SF2137

2021 Financial Assurance Estimate Form (with pre-plat construction)

PROJECT INFORMATION		
Latigo Trails Fil 9	9/9/2021	SF-XX-XXX
Project Name	Date	PCD File No.

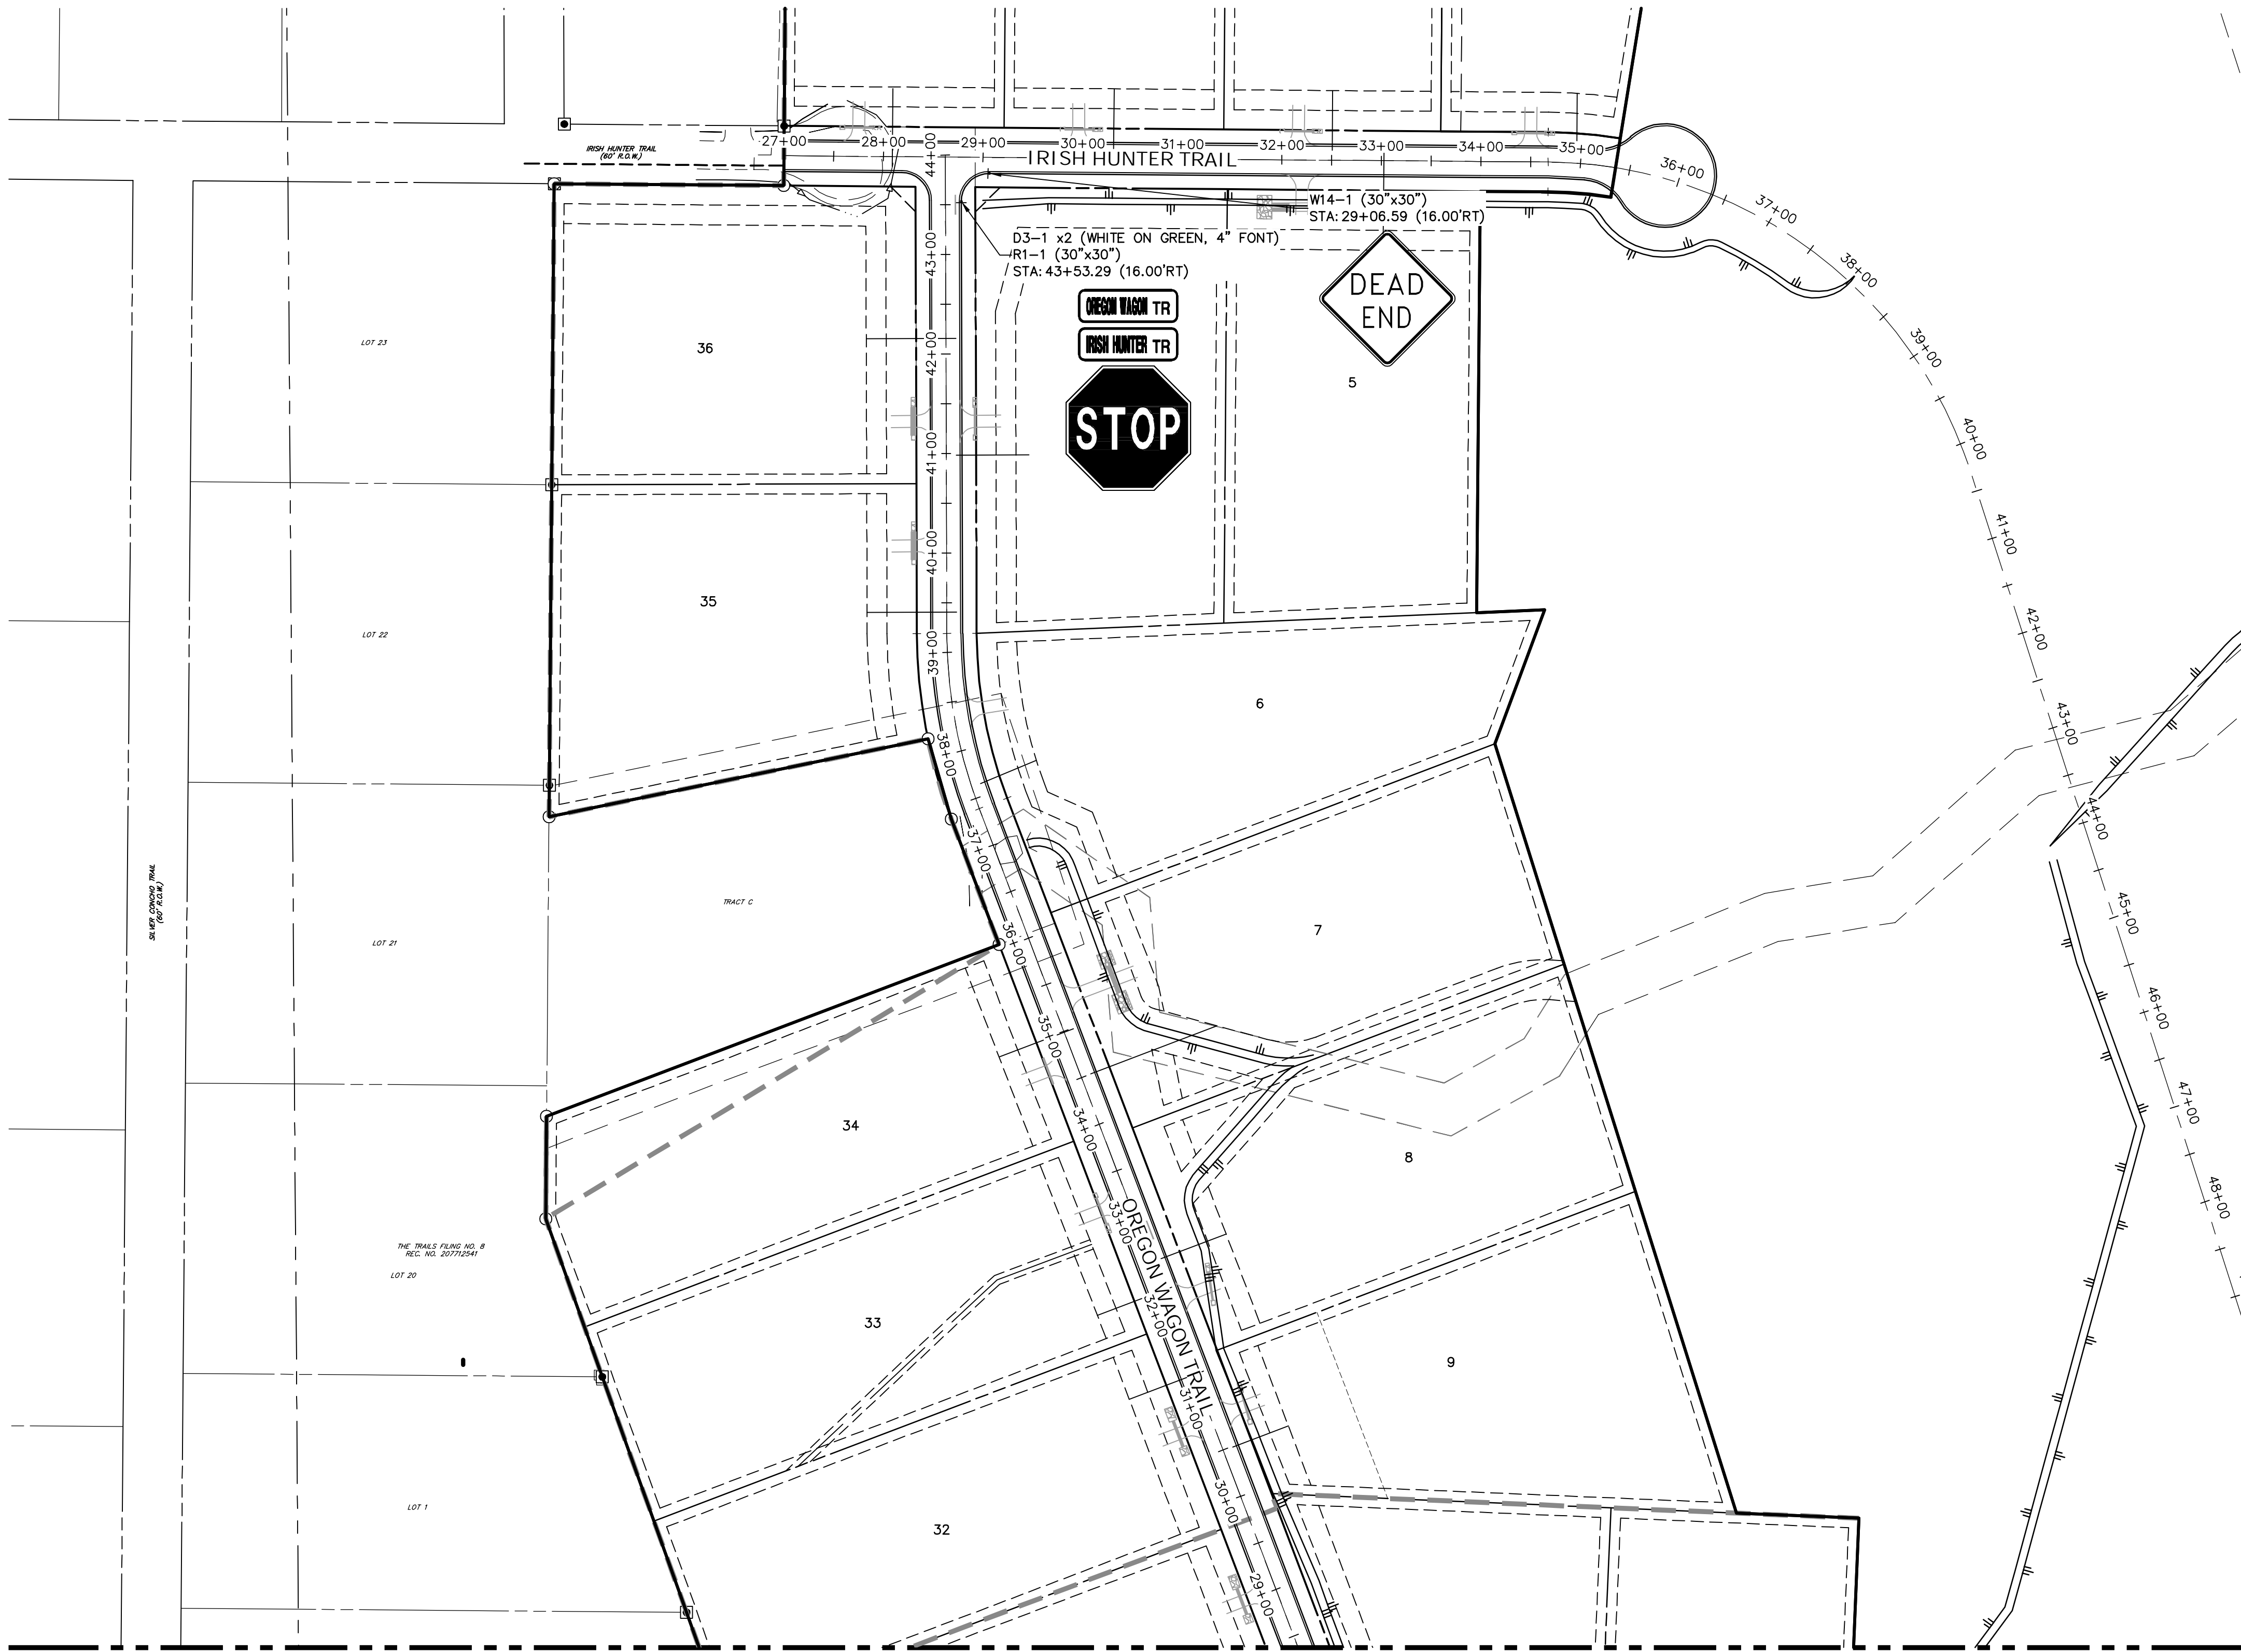
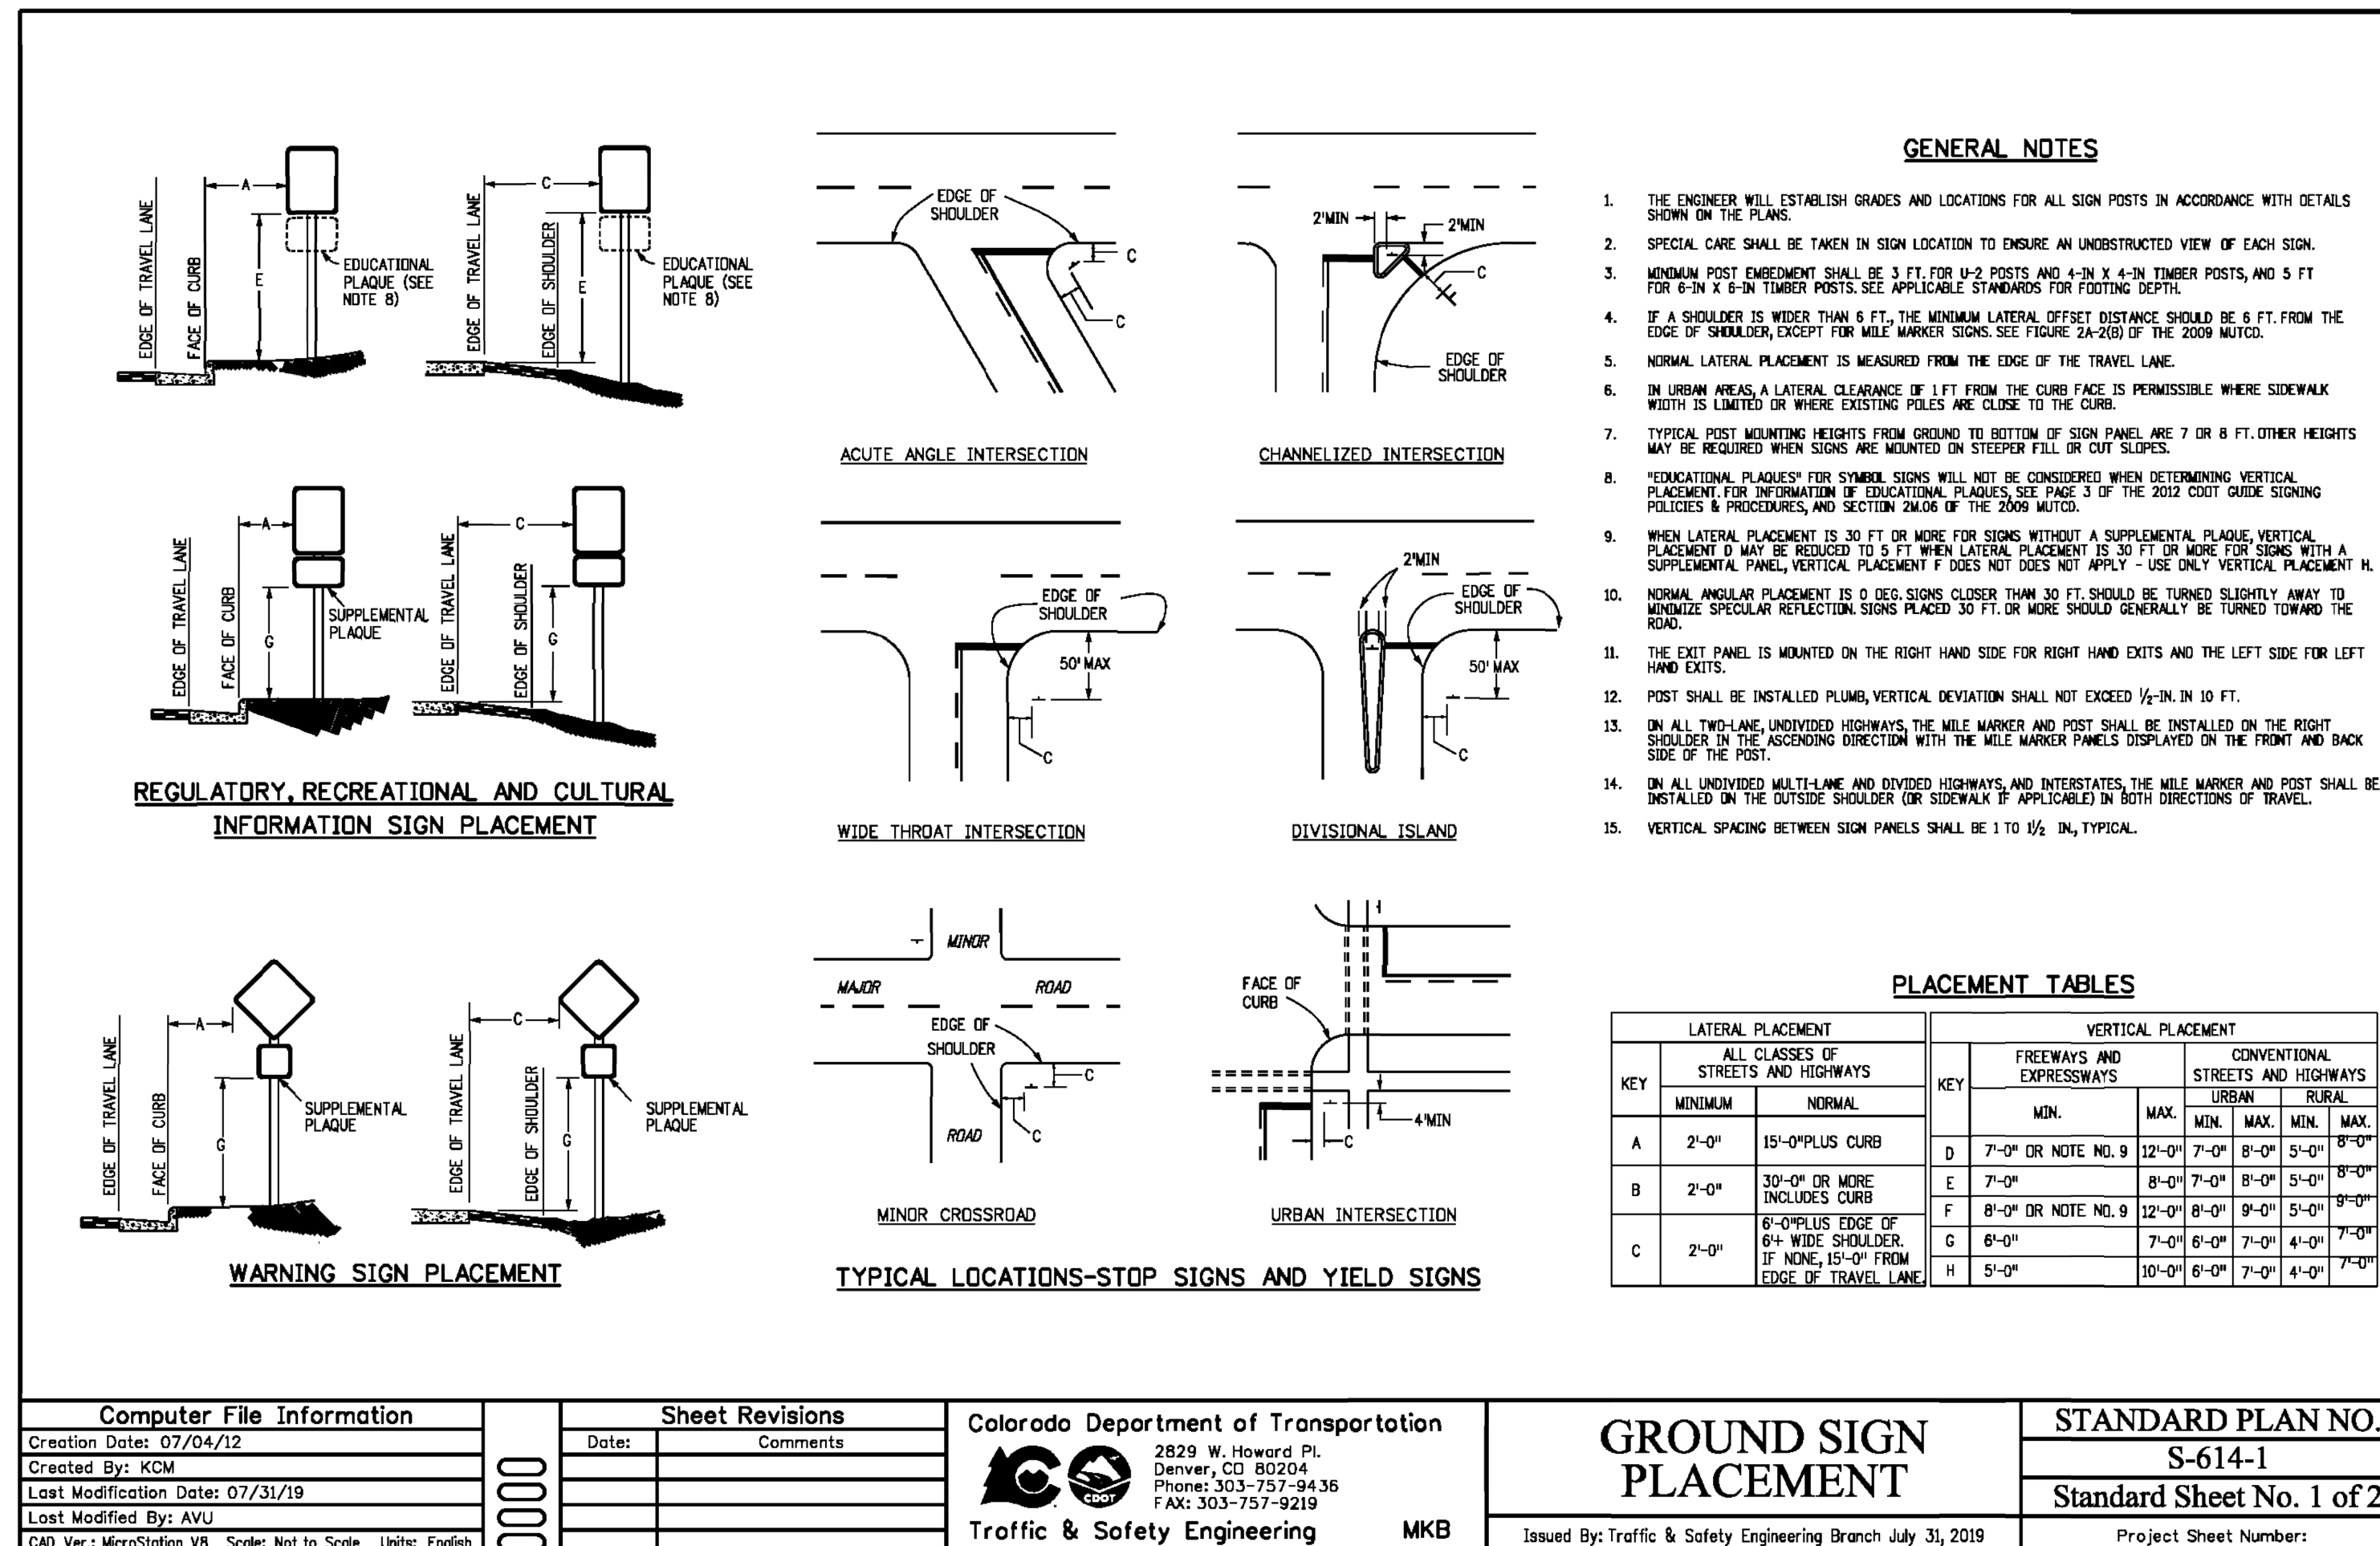
Update quantity per redline comment to the signage/stripping plan
